Case reference: NA29S.314232

DART+ West Railway Order - Dublin City to Maynooth and M3 Parkway

We, the below mentioned residents of the St Mochta's Estate would like to make the following submission.

The proposed closure of level crossings - specifically at the Coolmine Station

STATION DESIGN  
COOLMINE STATION  
FOOTBRIDGE: ELEVATION

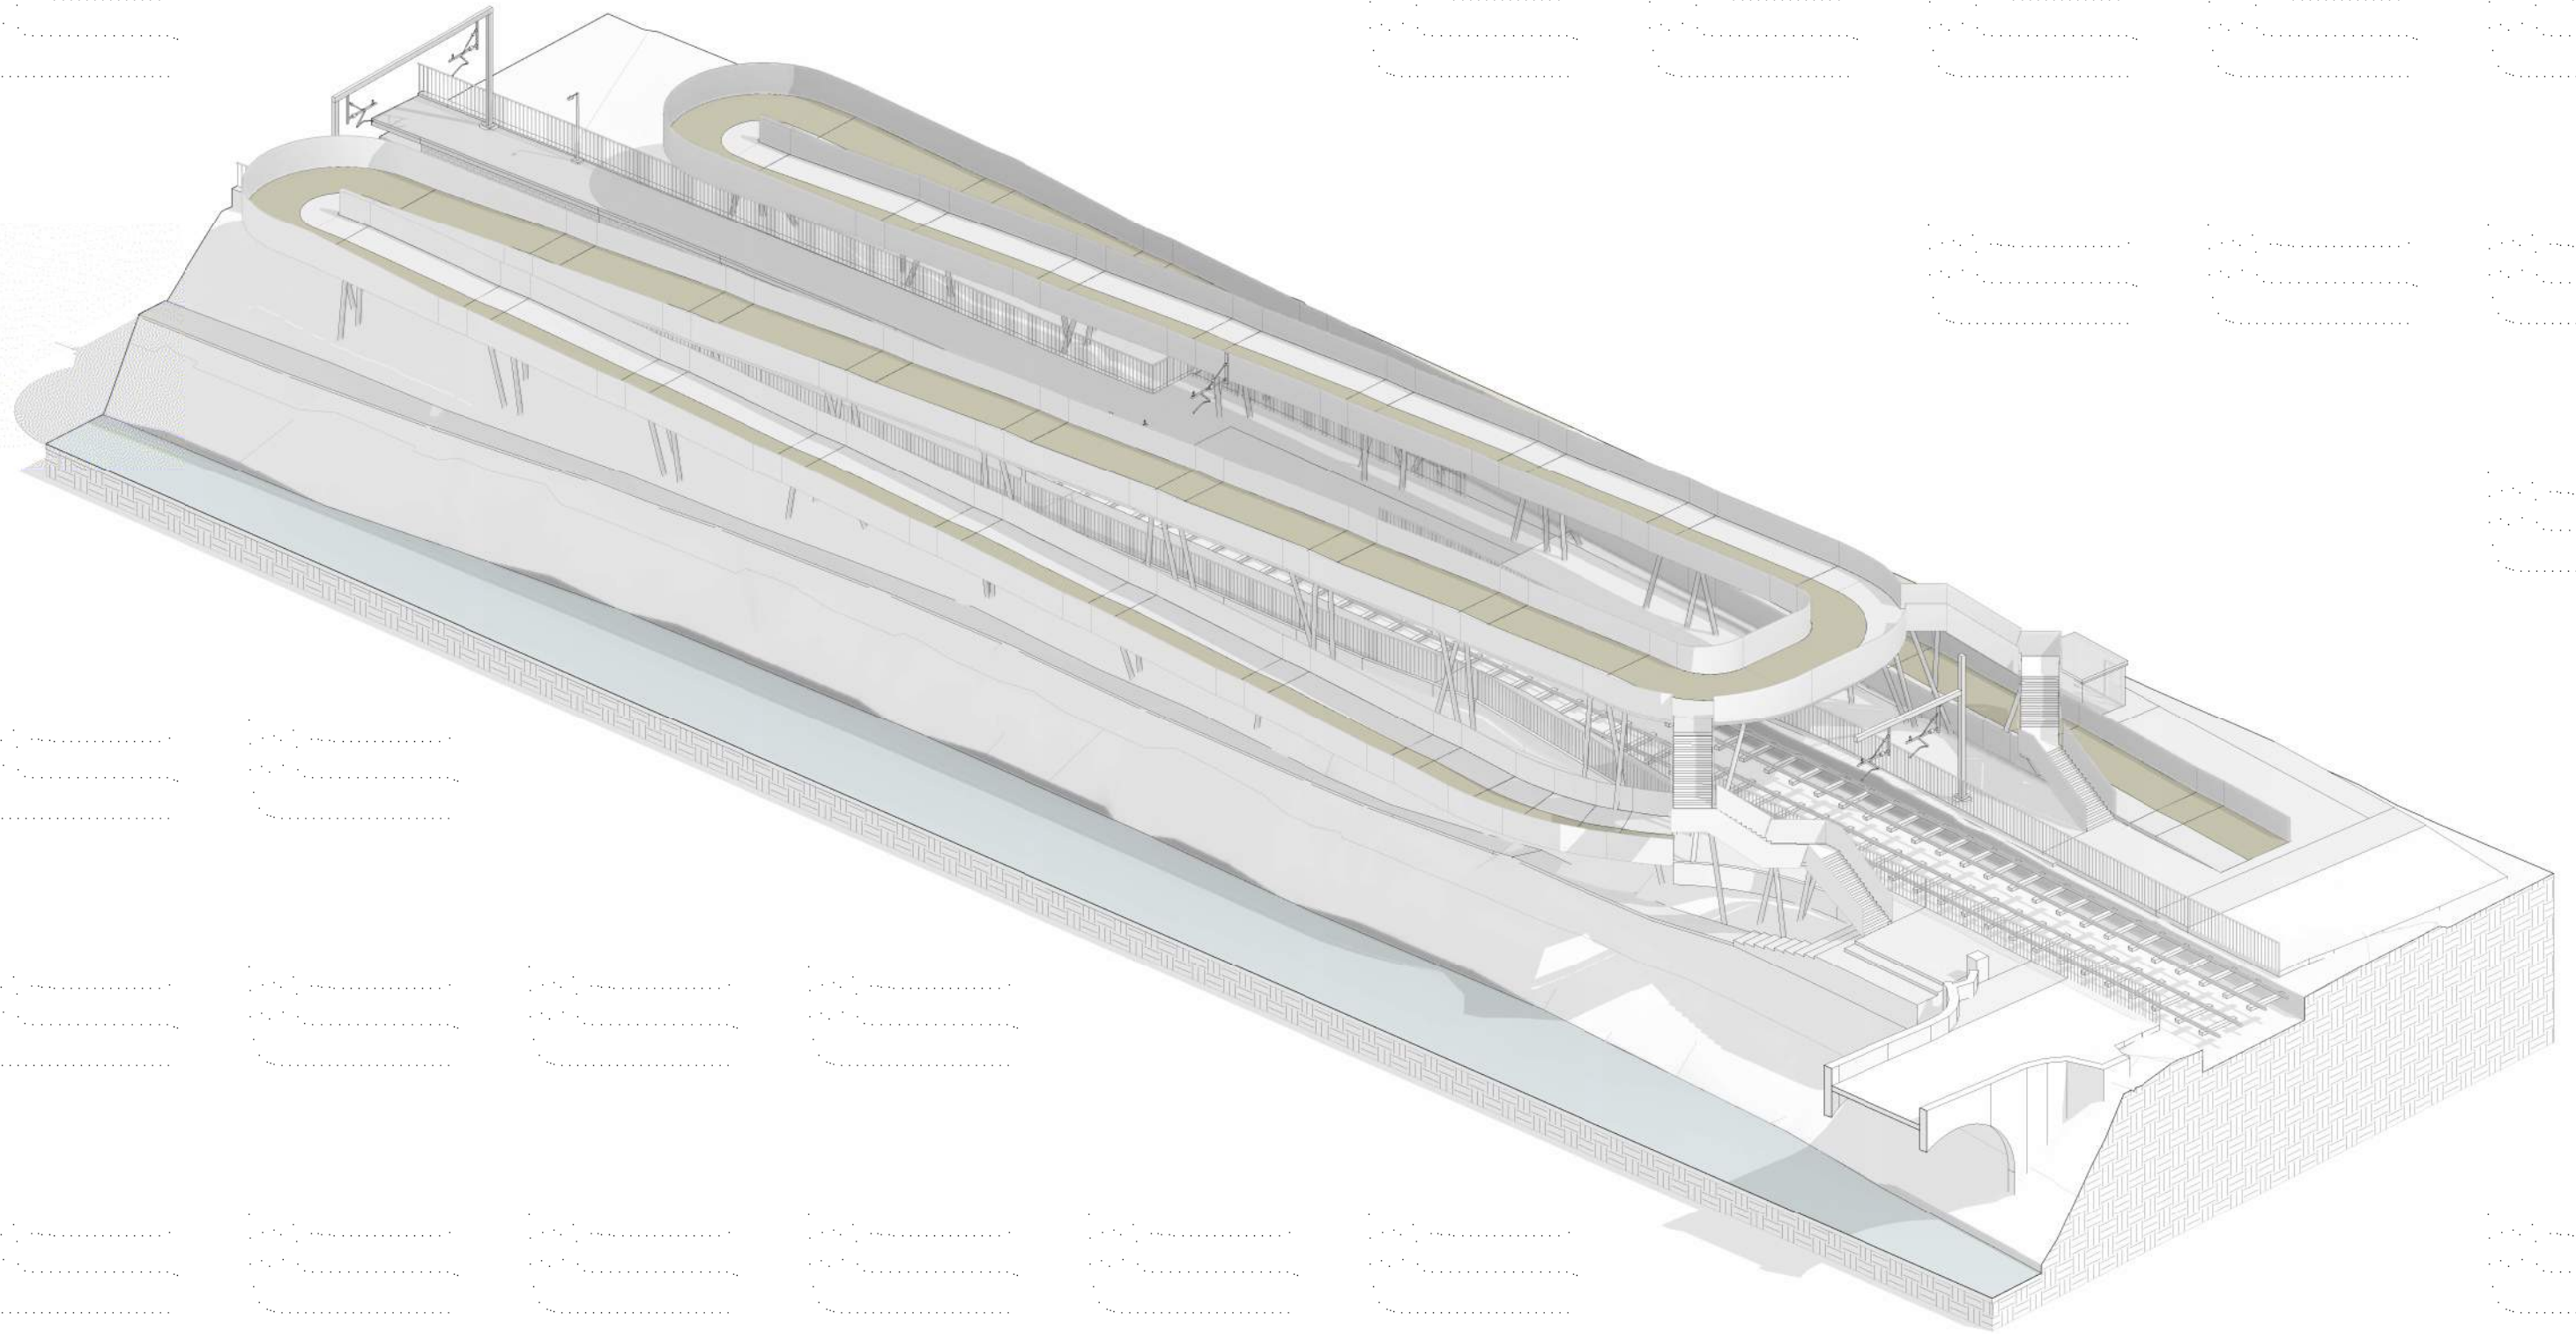
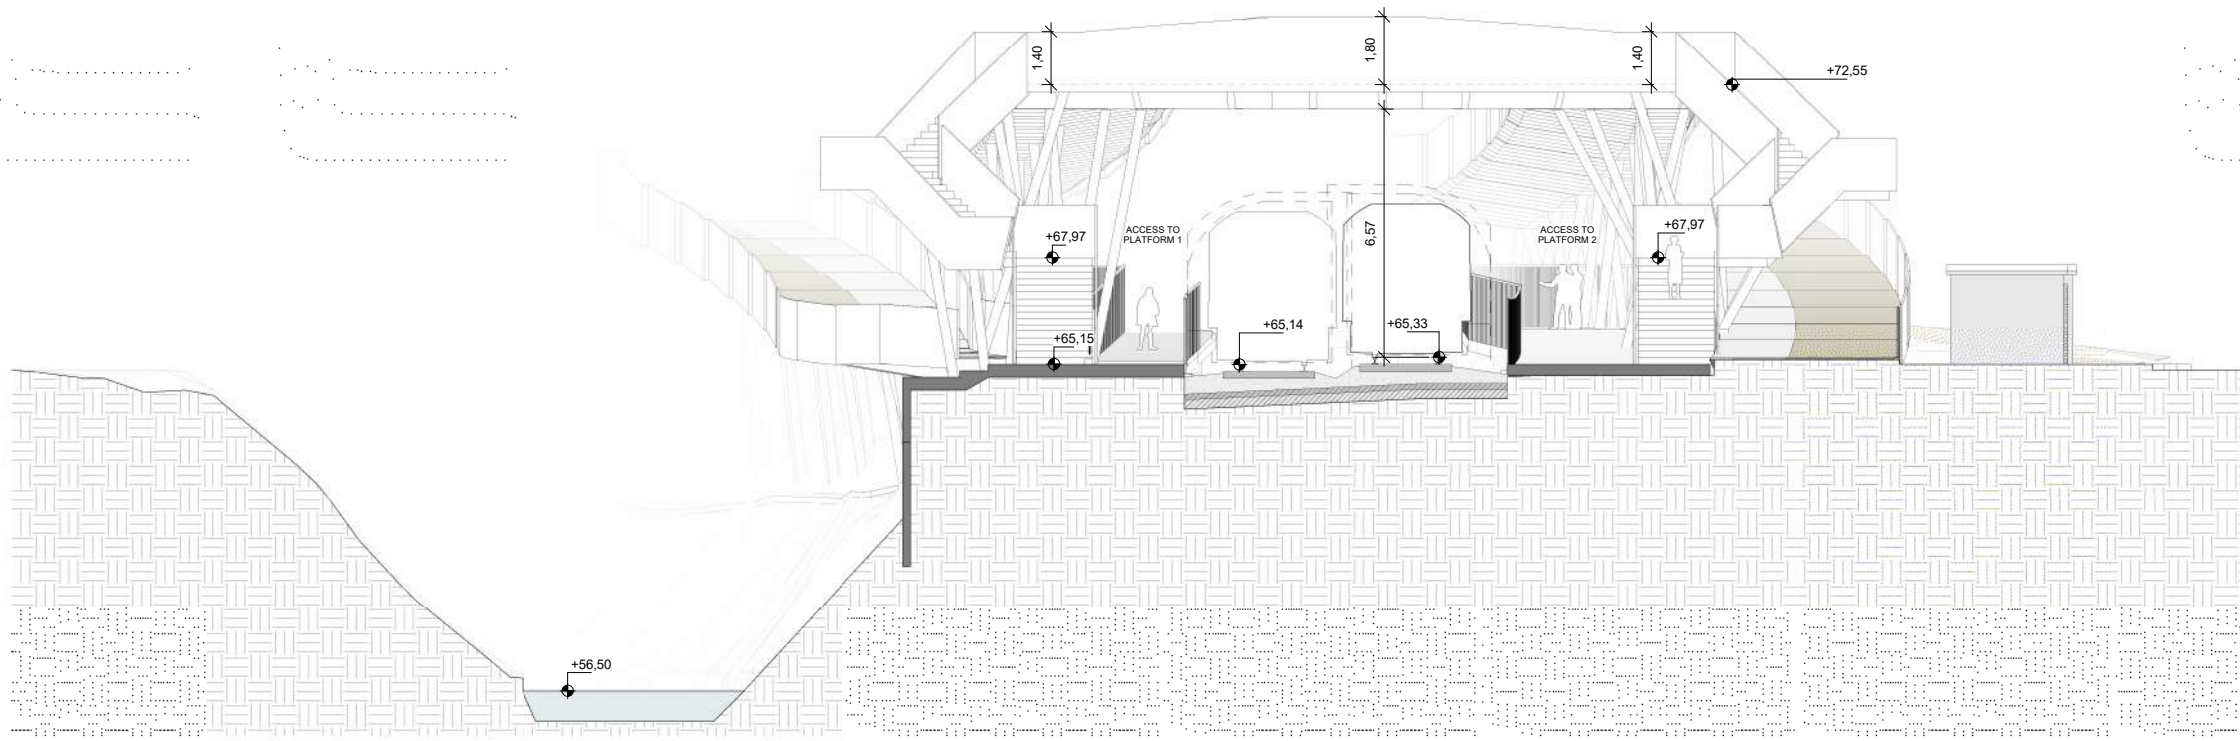
Proposed Pedestrian/Cycle Bridges – aesthetics

Not only is it ugly it would be an eyesore to what is a beautiful part of the Royal Canal/Deep Sinking at Coolmine. An area rich in nature and a local amenity we are lucky to have and maintain, the proposed bridge does not suit this part of the canal/area.

Proposed Pedestrian/Cycle Bridges – discriminatory

The recently opened pedestrian ramp at Pelletstown train station, also along the Maynooth line, has been highlighted as a concern for wheelchair users, or those with mobility concerns (source Access for All Ireland). The bridge proposed for Coolmine level crossing would provide similar challenges and a disgraceful alternative on offer to anyone with mobility issues.

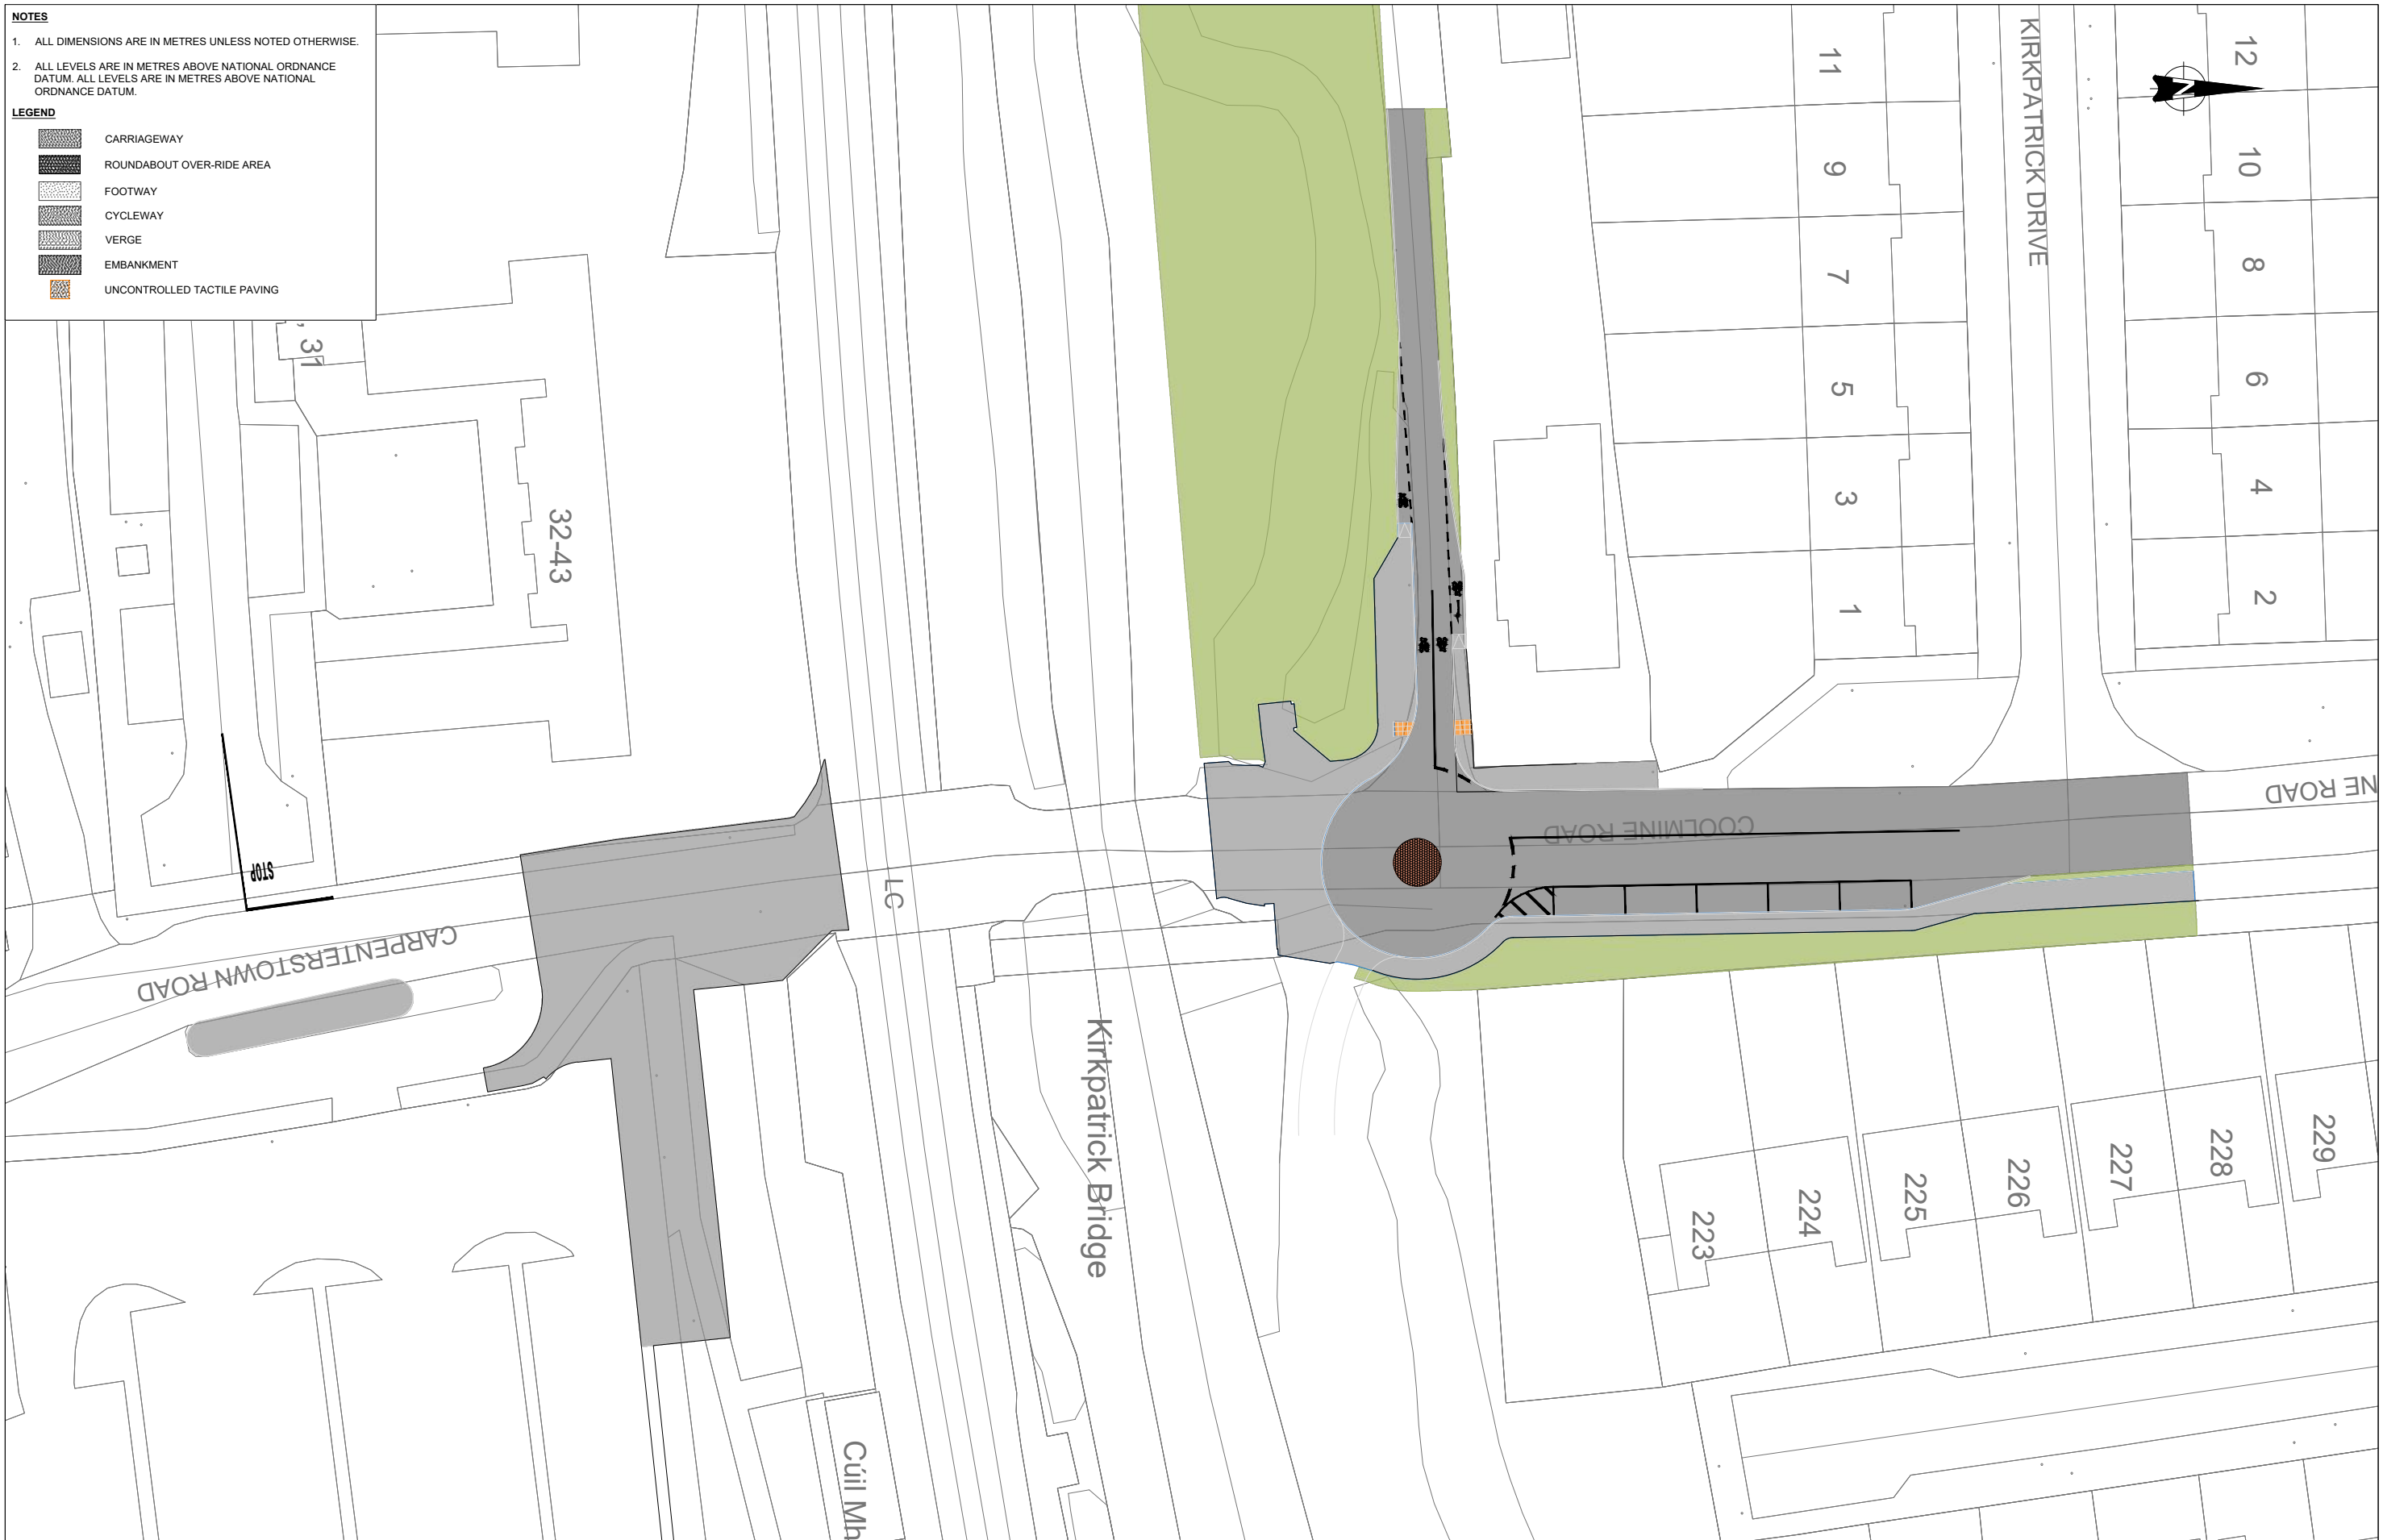
This level crossing must stay open and continue to allow through traffic crossing the Coolmine Road. The closure would force additional traffic through Castleknock Bridge and the Dr Troy Bridge which is already at capacity. Not all commuters use the train and it is selfish of Irish Rail to ignore road users. Journey times will be increased and will have further knock-on negative effects on our estate once the local council propose counter measures to the increased traffic. (Proposal of additional traffic bridge through the heart of our estate.)
